State of Washington
DEPARTMENT OF FISH AND WILDLIFE

August 6, 2025

SUBJECT: WDFW COMMENTS ON LP-25-00004 PFENNING PLAT

SHEET NAME
PRELIMINARY PLAT

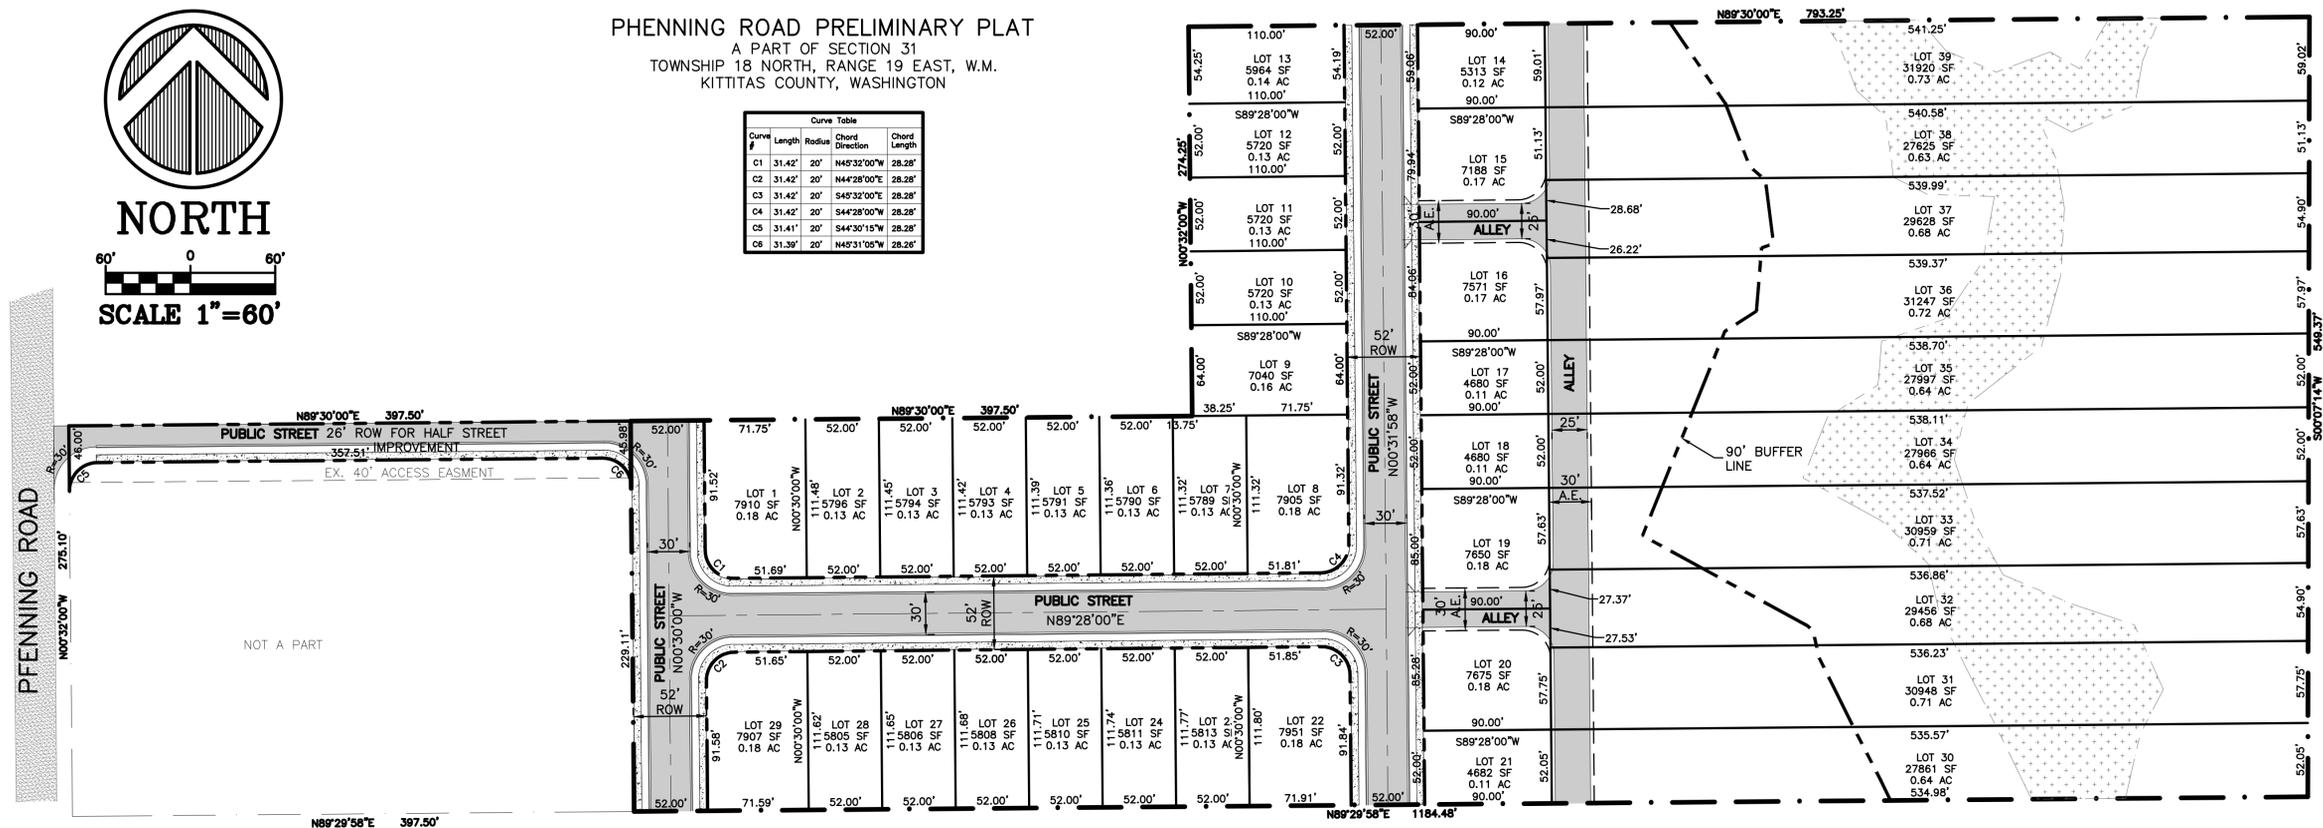
WDFW supports the applicant’s plan to install a permanent physical boundary, such as a split rail fence, to clearly mark the critical area boundary. **We recommend this wildlife friendly fence be installed prior to other ground disturbing work to ensure the protection of the critical areas and their functions and values.**

We also support and **recommend the proponent’s proposal to include the following language on the final plat map and on signs posted along the fence line:**

“No activity shall take place within designated wetland areas, including but not limited to the cutting of vegetation, dumping, filling, or construction. Wetland areas must remain in their natural state in perpetuity.”
